**NON-MATERIAL AMENDMENT TO PLANNING APPLICATION 21/00026/F
13 BLACKWOOD CLOSE, BODICOTE OX15 4BD**

This letter accompanies the on-line submission of a Section 96 non-material amendment application in respect of "Erection of dwelling house, garage and associated vehicular access off Oxford Road A4260 - re-submission of 20/02152/F", planning ref 21/00026/F.

PROPOSED DETAILED ELEVATIONS

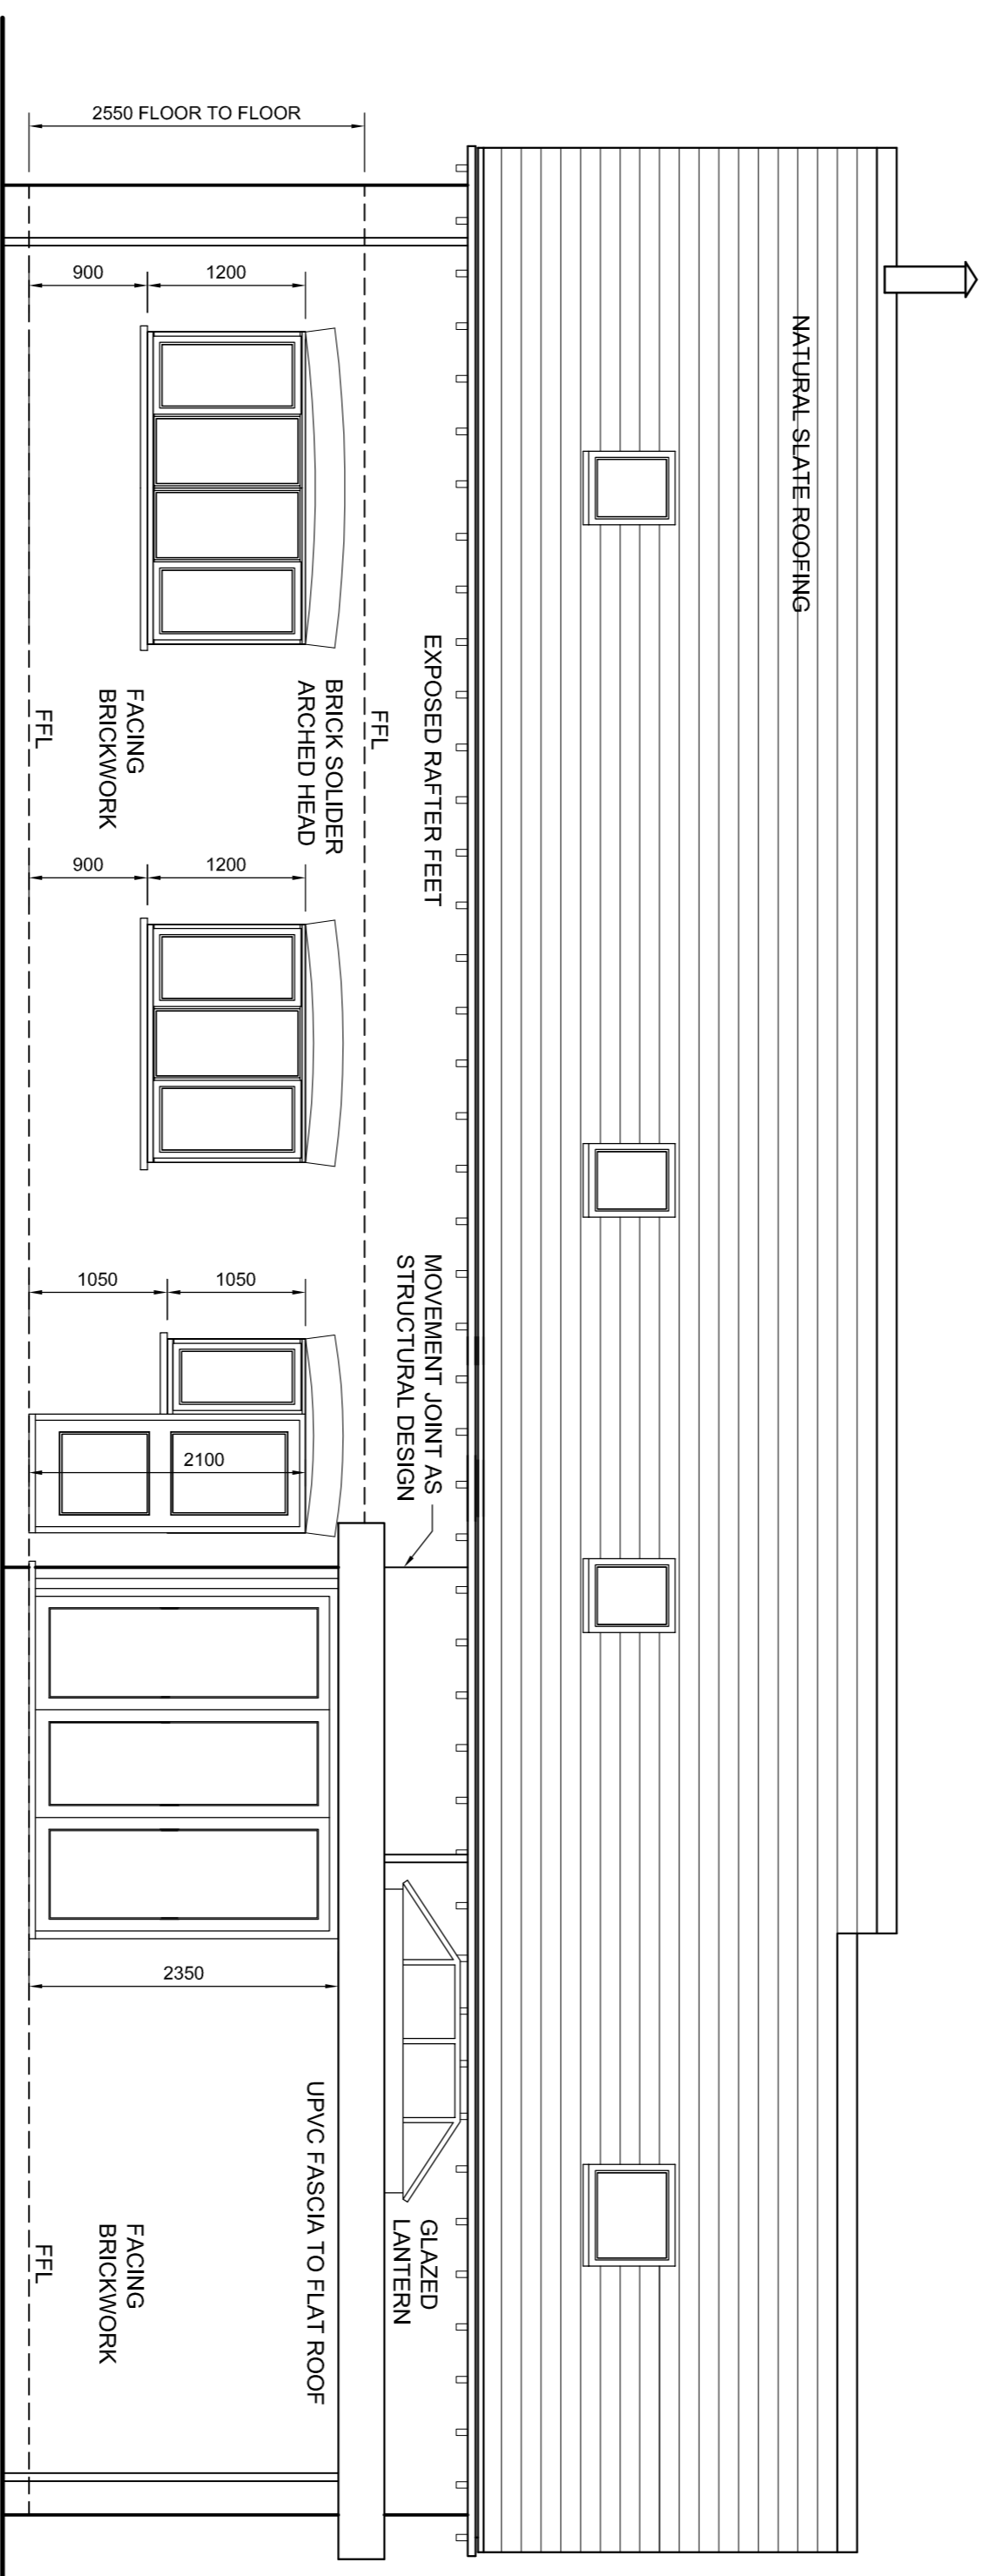
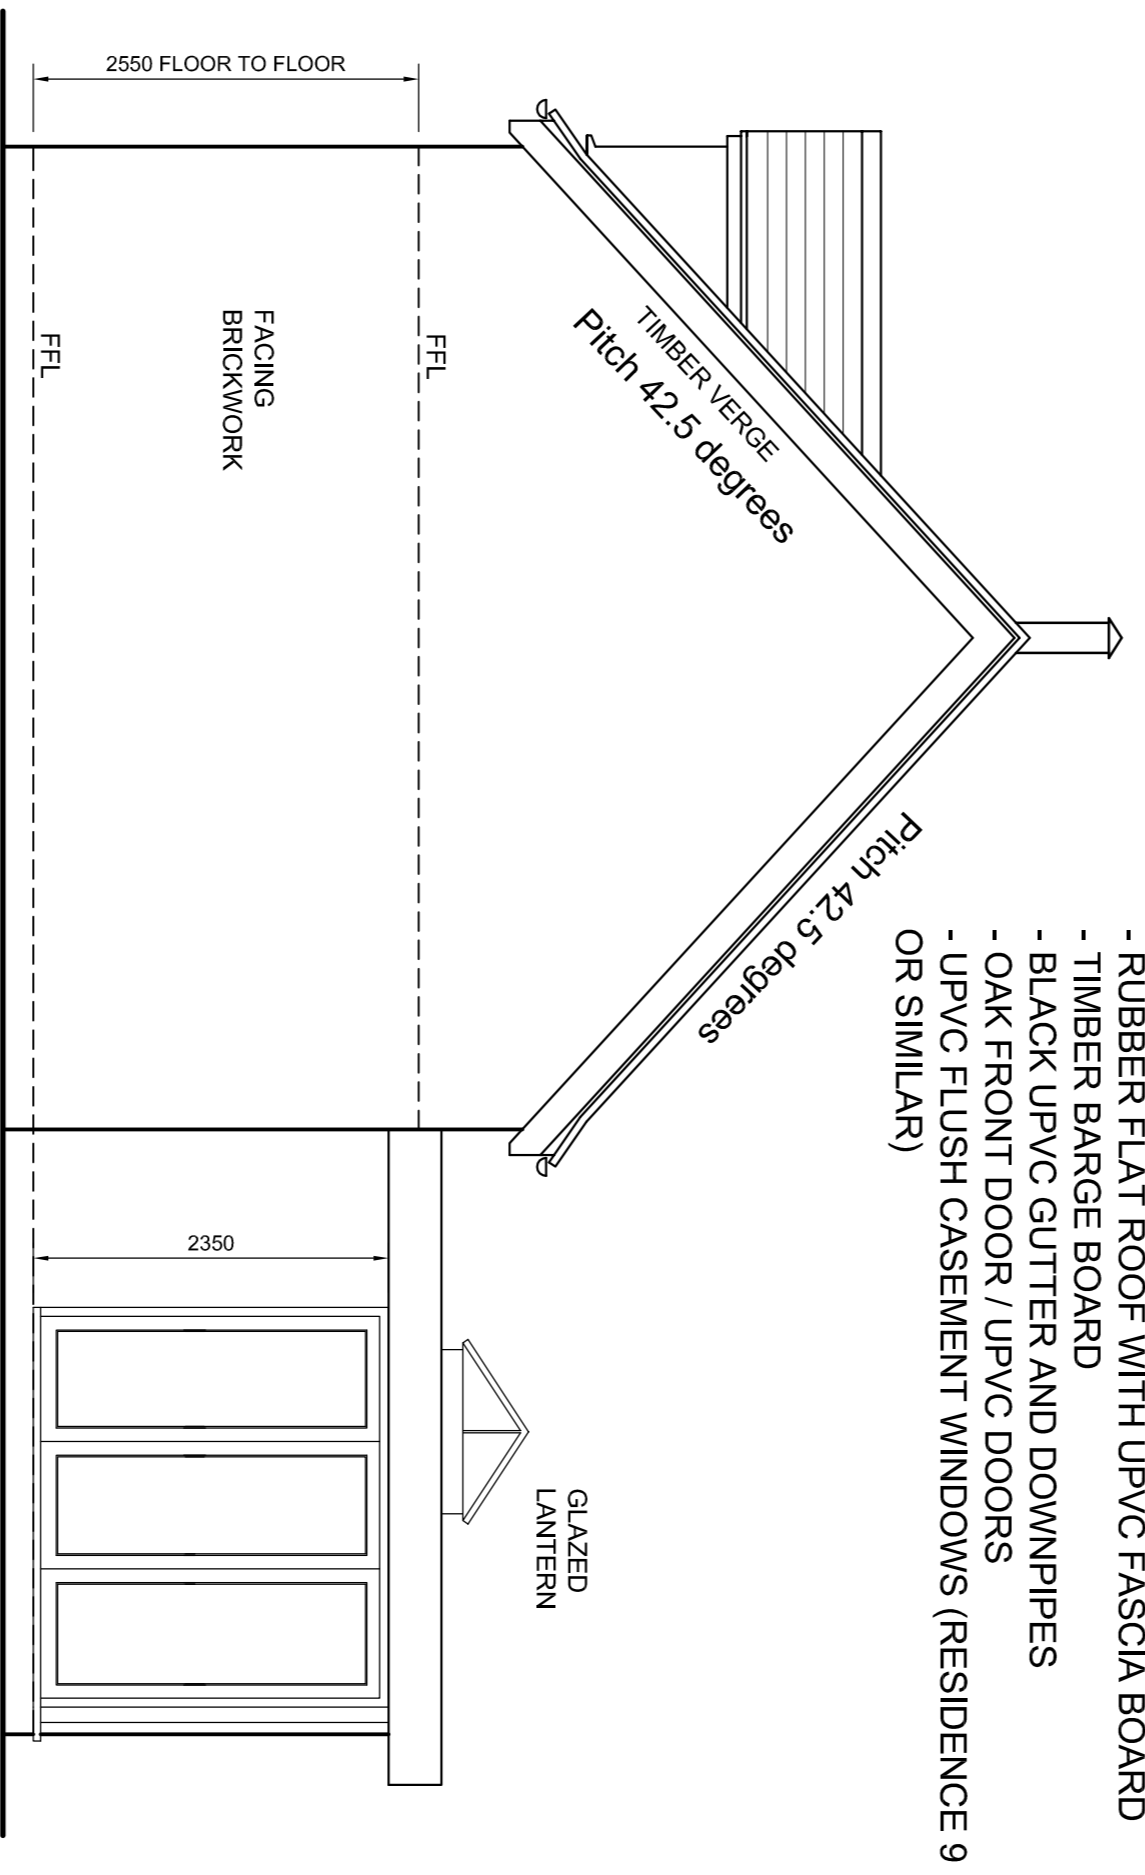
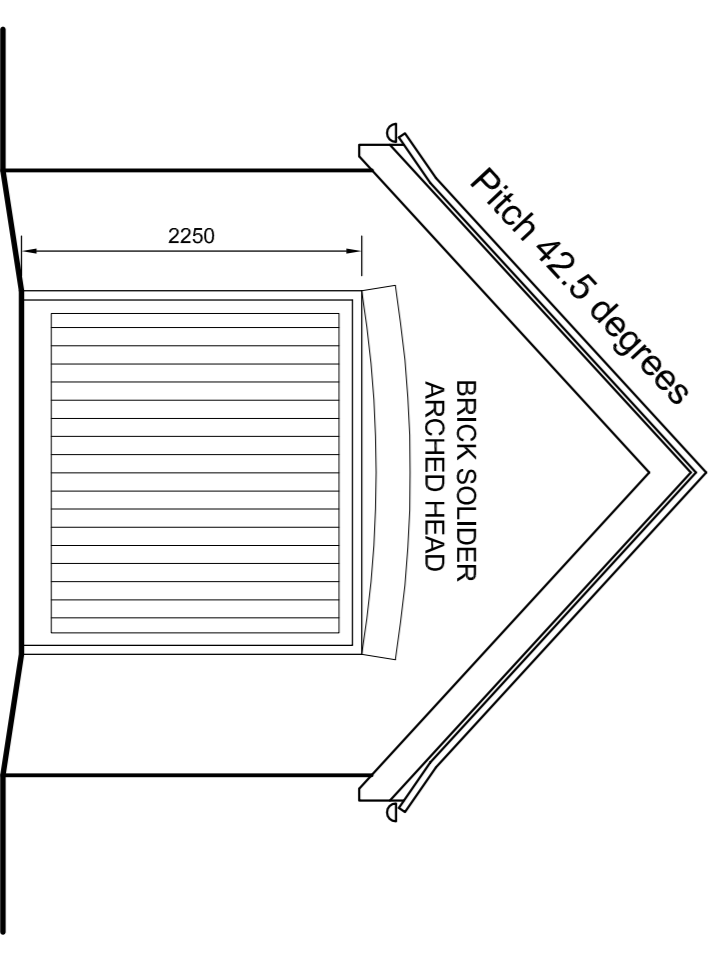
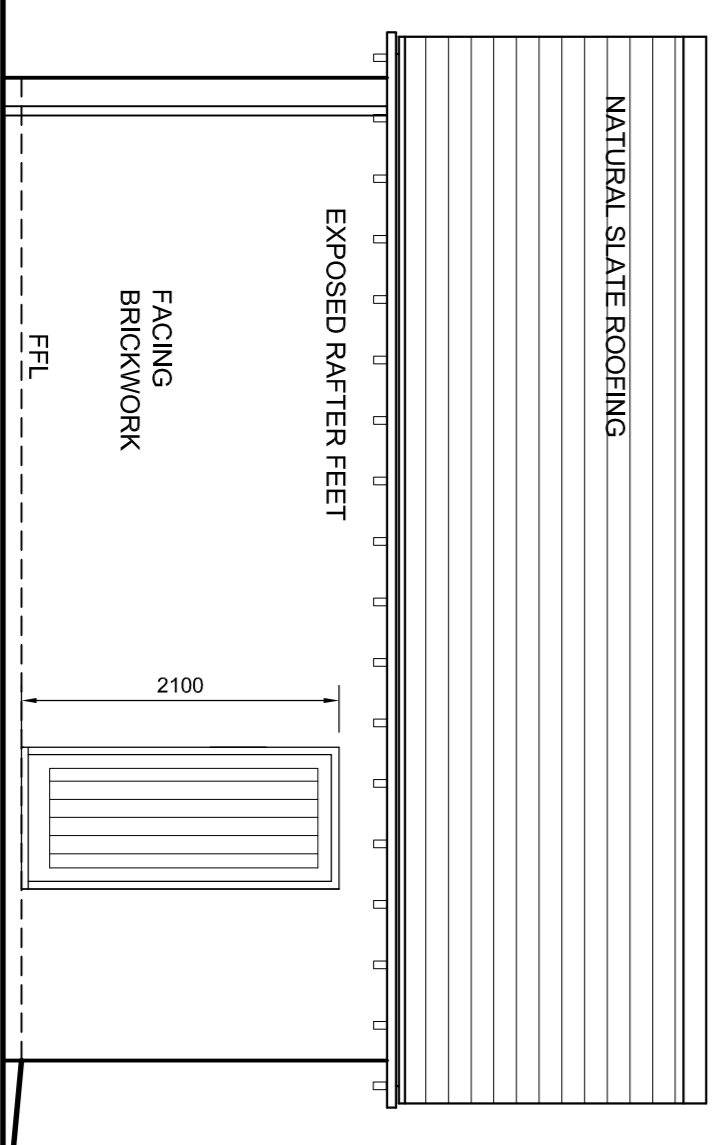
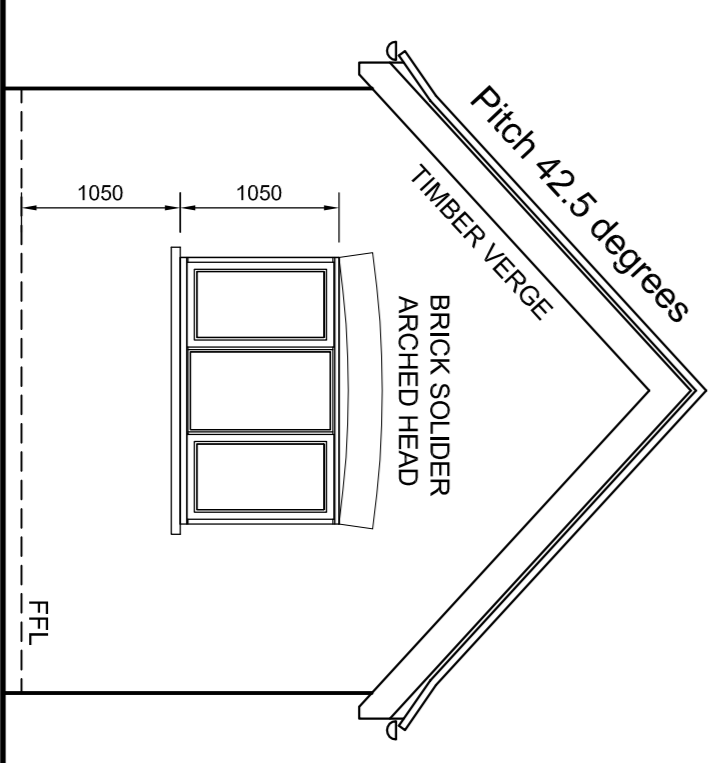
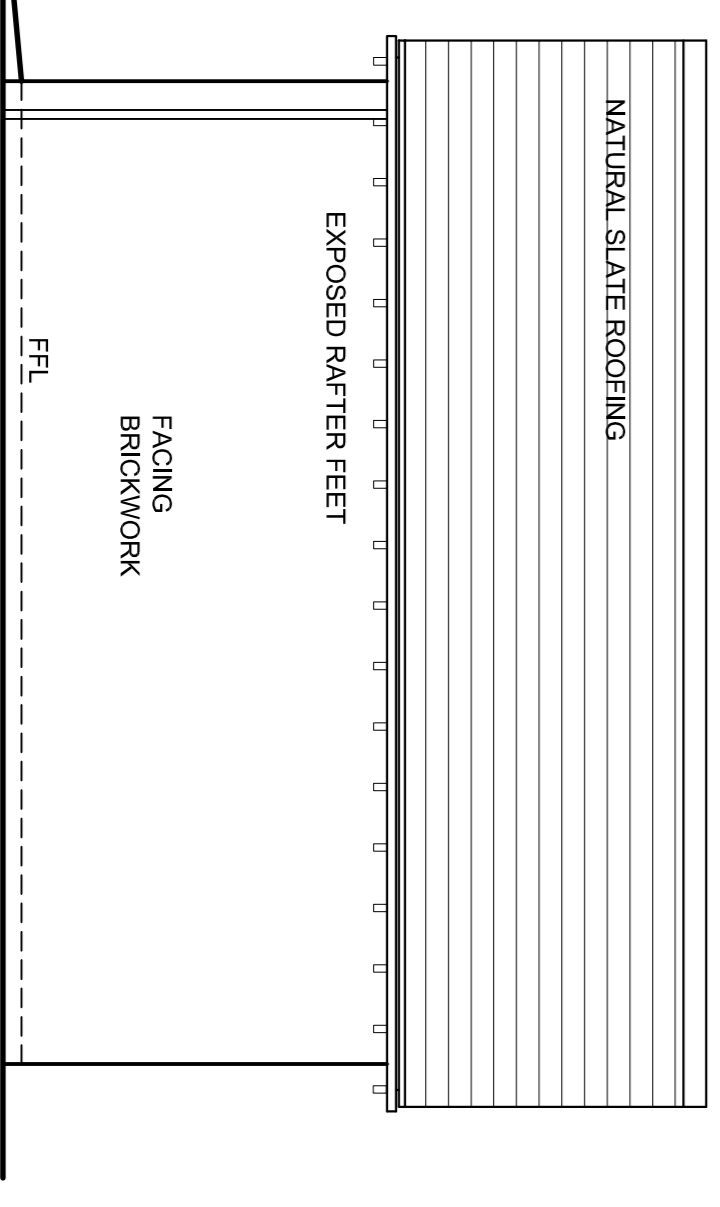
- The omission of two chimney stacks and insertion of a metal flue
- Rooflights at the rear of the property in a different position.
- A window instead of a patio door at the rear of the property.
